WELWYN HATFIELD COUNCIL – DEVELOPMENT CONTROL
DELEGATED REPORT

APPLICATION No:	S6/2011/2782/FP
APPLICATION Site:	97 Bramble Road, Hatfield

TITLE
**PROPOSED
BLOCK PLAN**

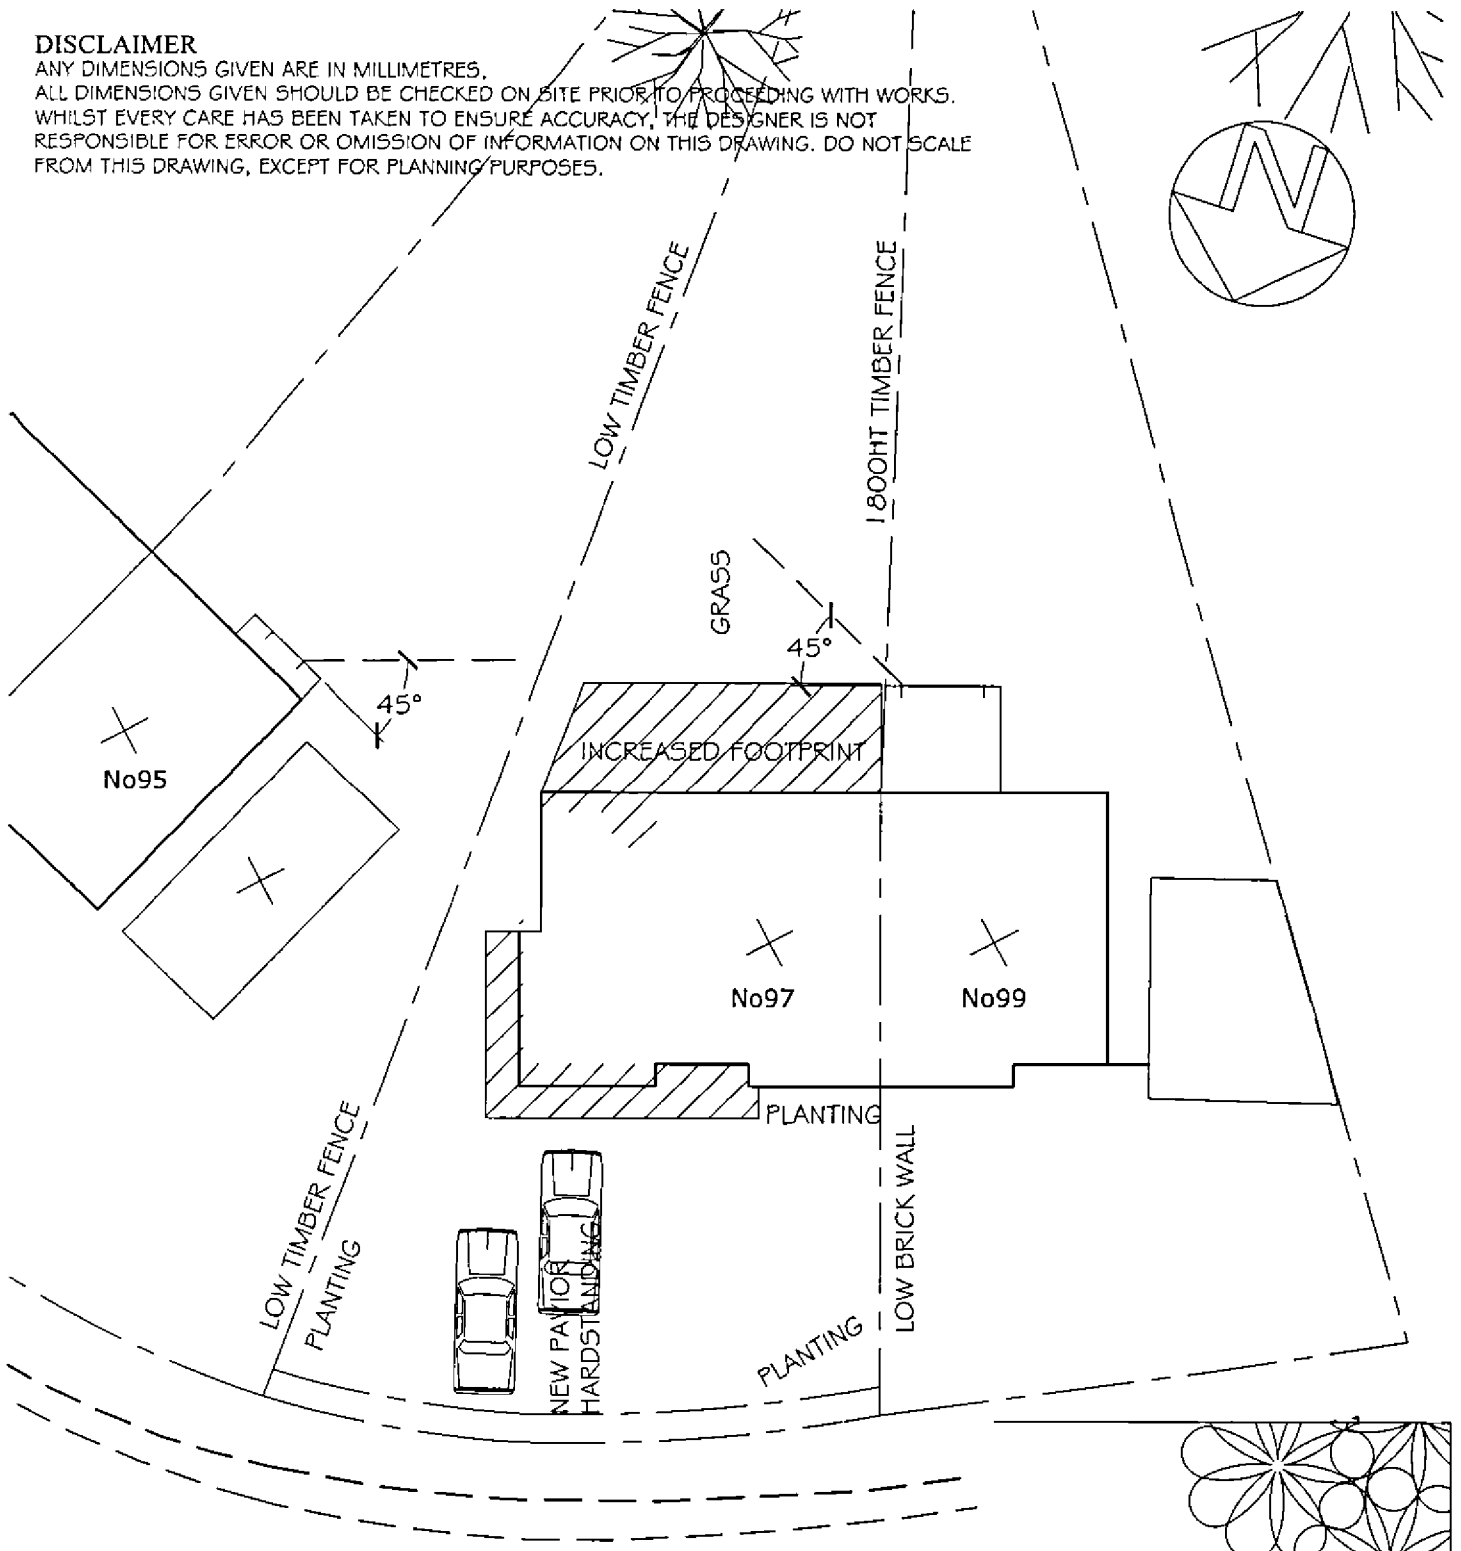
Car Parking: Policy M14 requires parking provision for new development to be made in accordance with the standards set out in the Council's supplementary planning guidance on parking. The proposal seeks the addition of a fourth bedroom. The proposal seeks to maintain three car parking spaces and therefore complies with the maximum standards for a four bedroom dwelling in accordance with policy M14 of the Welwyn Hatfield District Plan, 2005.

TITLE
PROPOSED
ELEVATIONS

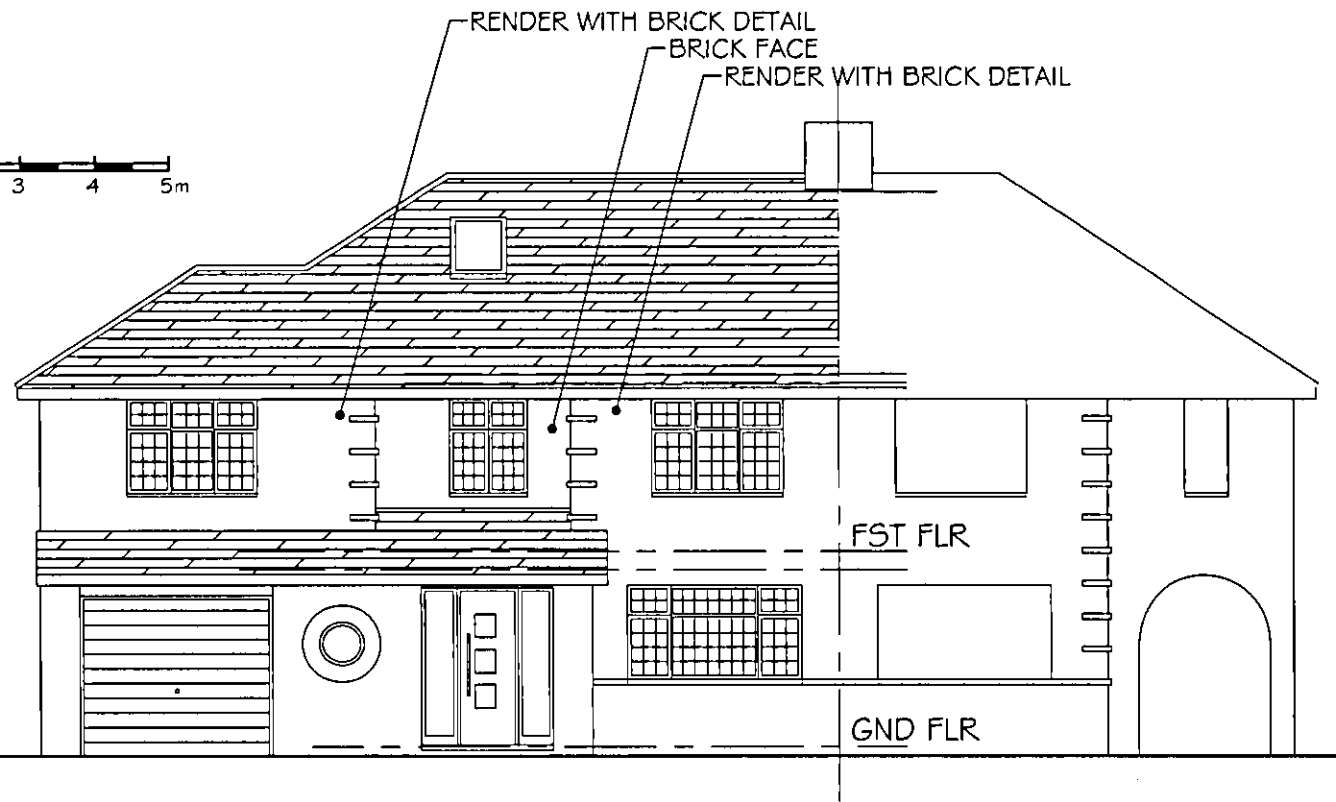
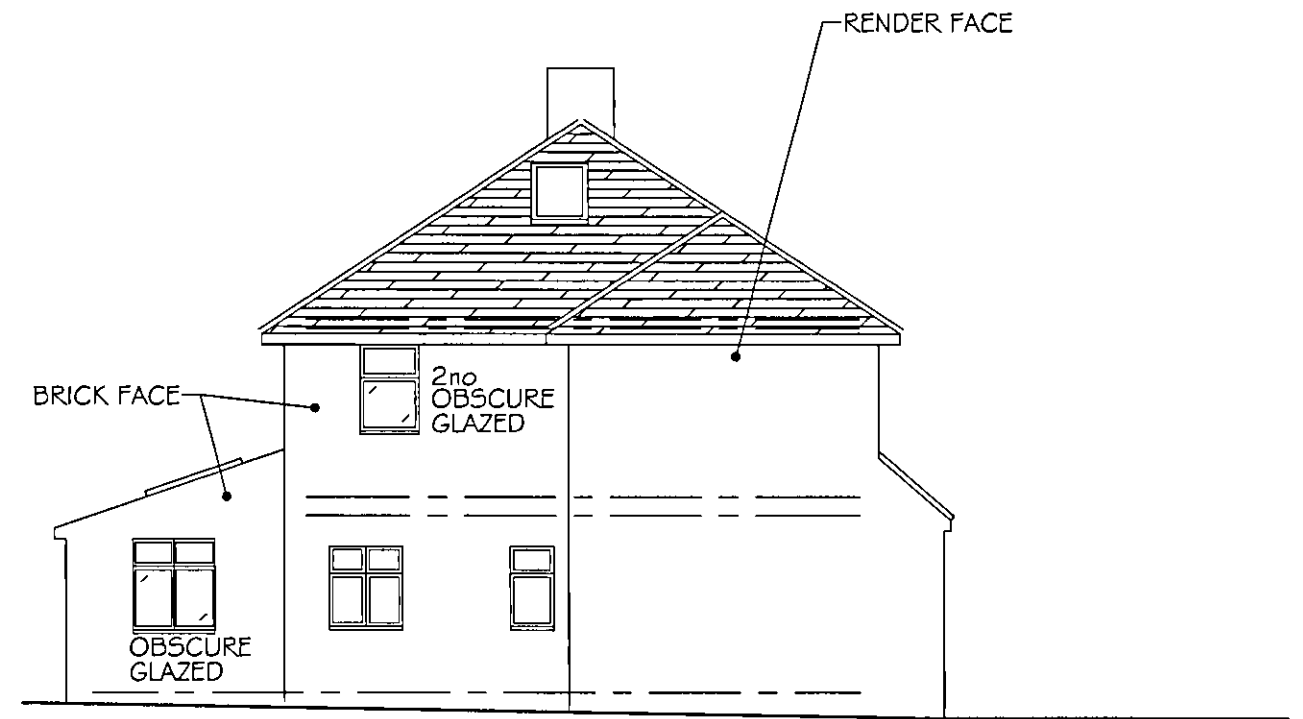
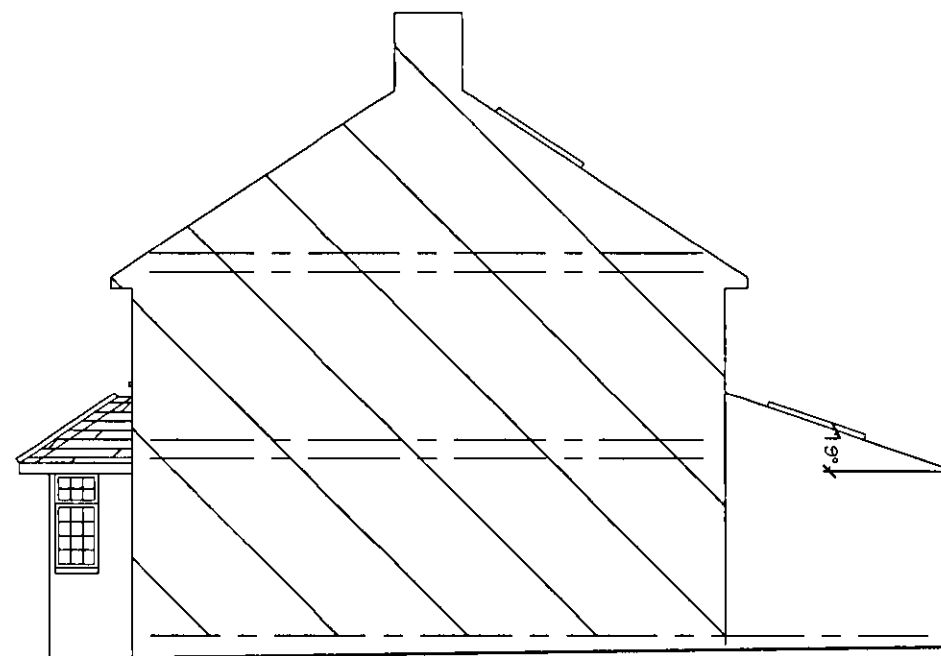
The proposals remain largely the same as previously submitted under planning application (ref: S6/2010/2999/FP) aside from the ground floor front and side extension. The proposal has considerably reduced the bulk of development to the front of the dwelling. When viewed from the side elevation with No.99, the proposed front extension protrudes 1.1m in depth. This proposed bulk of development to the front of the dwelling has been considerably reduced and appears more in keeping with the consistency of the built form of development within the locality. The proposed front extension therefore complies with policy GBSP2, D1 and D2 of the Welwyn Hatfield District Plan, 2005.

The proposed first floor side extension measures a total of 6.5 metres in height. The ridgeline is set 1.2 metres below the ridgeline of the existing roof. Policy D1 and the supplementary design guidance, paragraph 5.2 (v) states, 'for all multi-storey, two-storey and first floor side extensions, a minimum distance of 1m between the extension and the adjoining flank boundary must be maintained. This spacing is to prevent over development across plot widths and a terracing effect within areas of detached and semi-detached properties'. The proposed first floor element of the extension maintains a 1 metre separation space. Other properties within the vicinity of No.97 have incorporated a first floor side extension. The proposal at No.97 does not detract from the design and character of the surrounding area at first floor level and therefore complies with policy GBSP2, D1 and D2 of the Welwyn Hatfield District Plan, 2005.

The proposed single storey rear extension extends beyond the rear wall by three metres. The neighbouring property, No.99 Bramble Road already has a single storey rear extension with a flat roof. The proposed pitched roof rear extension measures the same depth as that at No.99 and therefore is not considered to impact on the amenity of No.99.

On the eastern side elevation of the proposed single storey rear extension is a window which is shown to be obscure glazed. The window is not considered necessary for the purposes of sunlight/daylight to the rear extension as it is south facing and the rear elevation comprises of a large five panel bi-folding patio door with a window either side and three rooflights within the pitched roof. The new window proposed on the side elevation of the existing dwellinghouse which would form part of the new kitchen is shown to be obscure glazed. The window proposed on the first floor side elevation of the dwellinghouse is shown to be obscure glazed. The proposed first floor side extension maintains a 1 metre separation space at its closest point to the boundary with No.95 and measures approximately 7 metres from the flank wall of No.95. The proposed first floor extension is therefore not considered to impact on the amenity of adjoining neighbours.
